**London Luton Airport DCO:
Review of the “Applicant's Response to
Written Questions NE.2.1 and NE.2.2 -
Demand Forecasts” [REP8-037]
Host Authorities
January 2024**

Brief Review of REP 8-037

Figure 2.5: Comparison of Central UK GDP Forecasts in the Original and Updated Forecasts (Index: 2022 = 100)

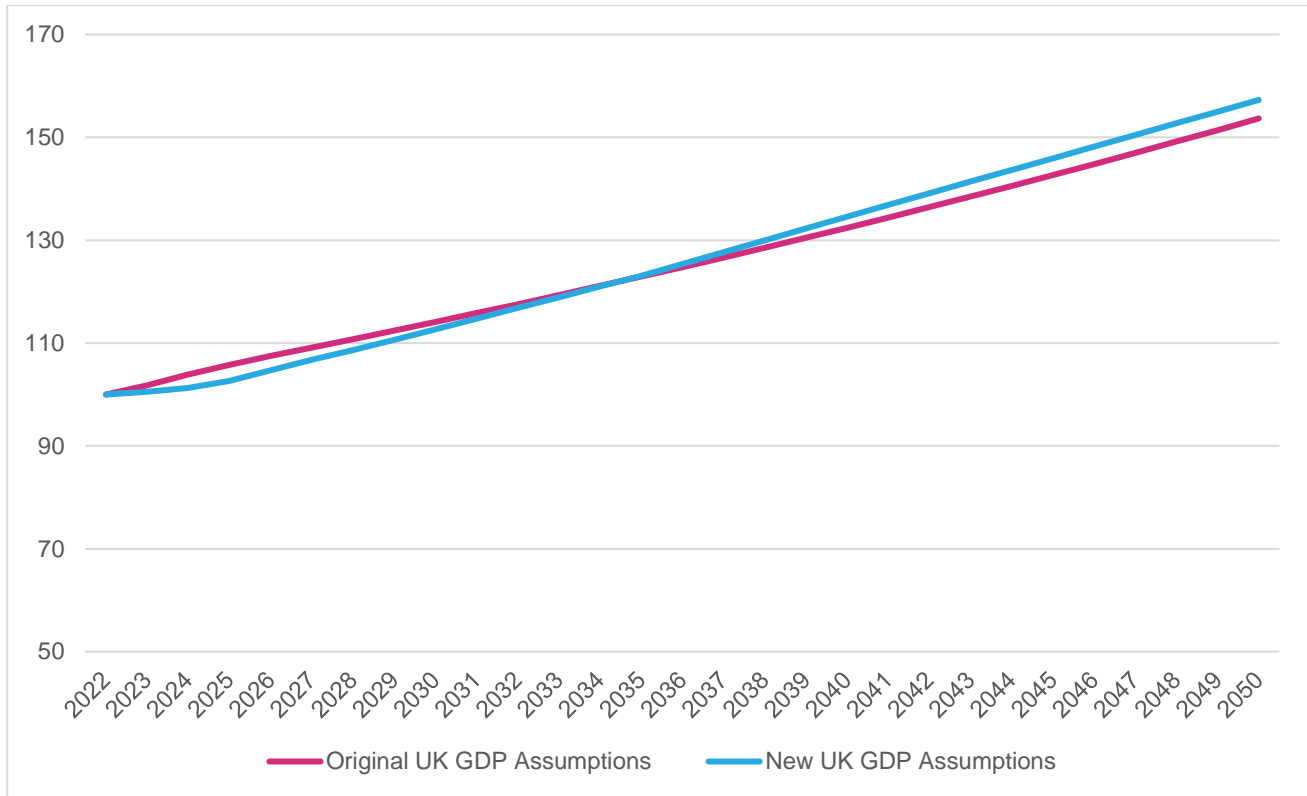
2. The forecasts presented by York in general show an increase in both UK and foreign GDP assumptions over the period to 2050, with as York points out often lower growth in the short to medium term, and faster growth in the longer term. This is shown in the document's Figures 2.5 and 2.6, from the assumptions used in its Need Case. It is noted that this implies that the economic forecasters consider that the World's prospects have improved over the last two years.

3. The improvements in GDP assumptions are not large, especially for the important UK GDP assumptions which is one of the growth drivers in categories covering about three quarters of all passengers (see for example Figure 2.5). However, the impact on forecasts demand appears more dramatic with, for example, the new Central Forecast being in 2050 at the same level as the Original Faster Growth forecast (Figure 3.2). There was no corresponding figure to this in the Need Case, and its value is reduced by the forecasts being presented on an index basis. However, if the new Central growth index of 190 in 2050 is applied to a UK passenger base of 221.6 mppa in 2022 (UK CAA Statistics), a total UK forecast in 2050 would be some 420 mppa. The most recent DfT forecast (March 2023) extends only to 2040, but applying York's growth rates (Table 3.1) to the DfT's 2040 end-point indicates a higher figure of 437 mppa. In other words, the new LR forecast may in fact be lower than the most recent DfT forecasts.
